From: Zac Denton
Sent: 01 October 2018 13:07
To: Karen Parsons
Subject: FW: 6 Langmeads Close

From: Kevin Burke [REDACTED]
Sent: 27 September 2018 22:07
To: Zac Denton
Subject: 6 Langmeads Close

Please find measurements listed below as requested regarding the North elevation.

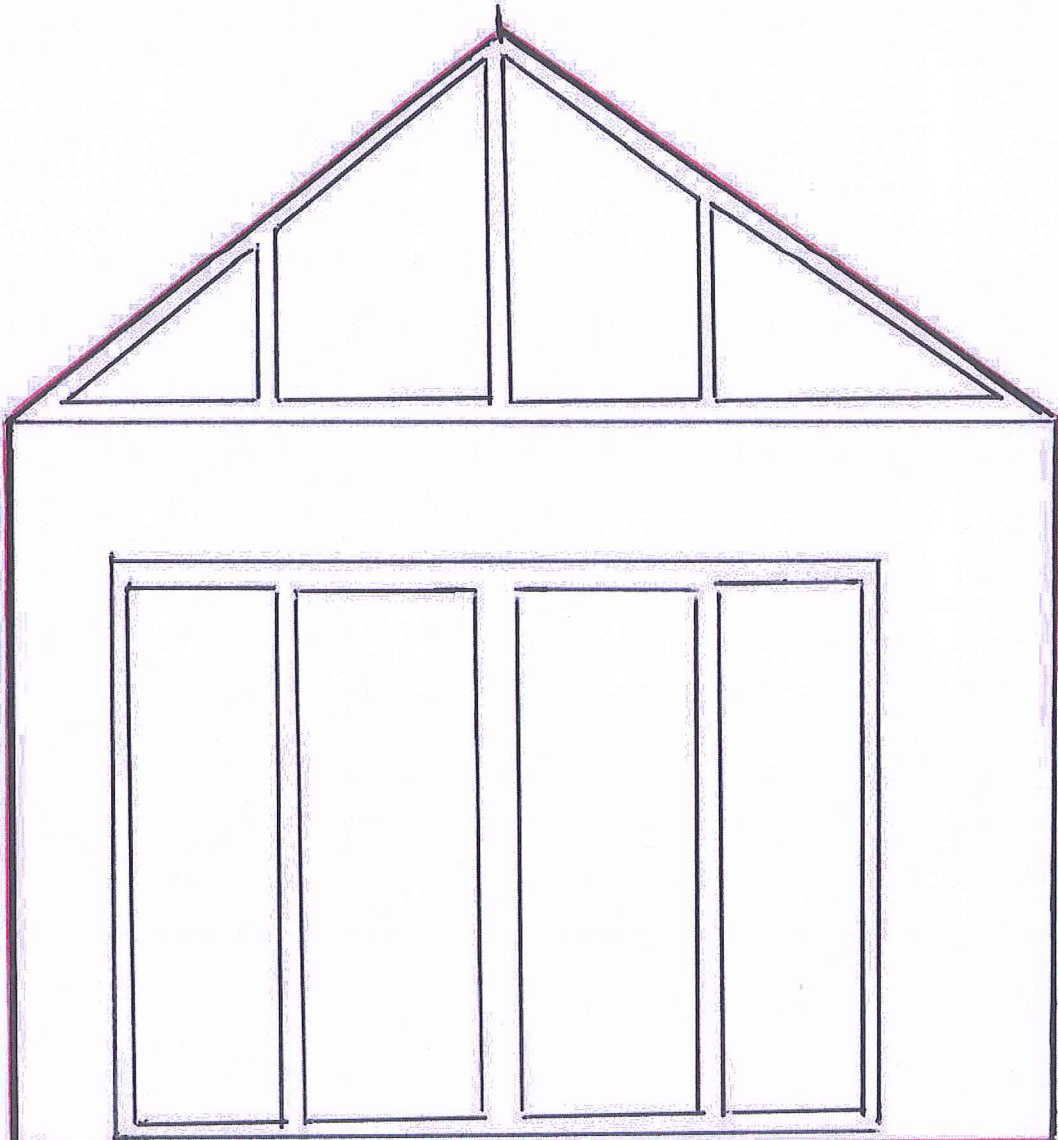
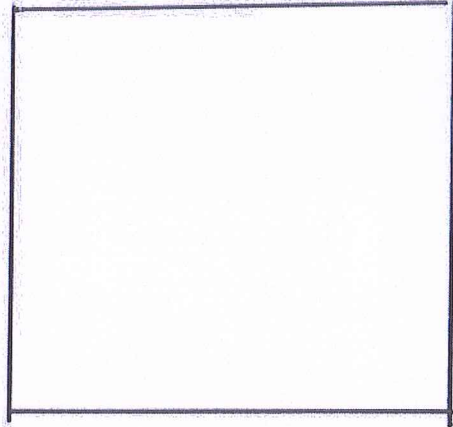
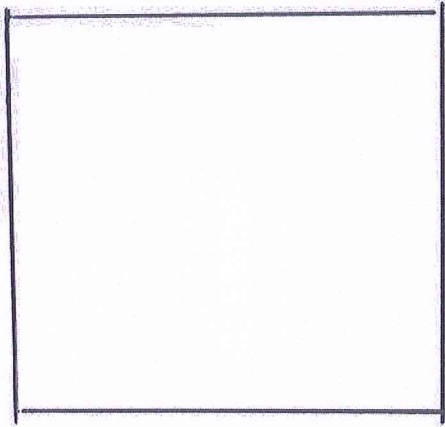
The external walk height for brick work is 1.86meters.

Windows are 0.4 meters in height giving a total height of 2.26 meters.

The fan light windows will be of obscure opaque glass but as discussed with our neighbour we would agree to omit the windows on the North elevation giving a total height of brick work of 2.26 meters which our neighbour has stated resolves their objection.

The internal wall height is 1.66 meters of brick work, 0.4 meters window height, totalling 2.06 meters. However without windows the brick work would total 2.06 meters.

The application will be assessed and determined as it has submitted. Please note that if the application were to be approved, it would be approved with the fan lights in place, and would therefore need to be built in accordance with these plans.
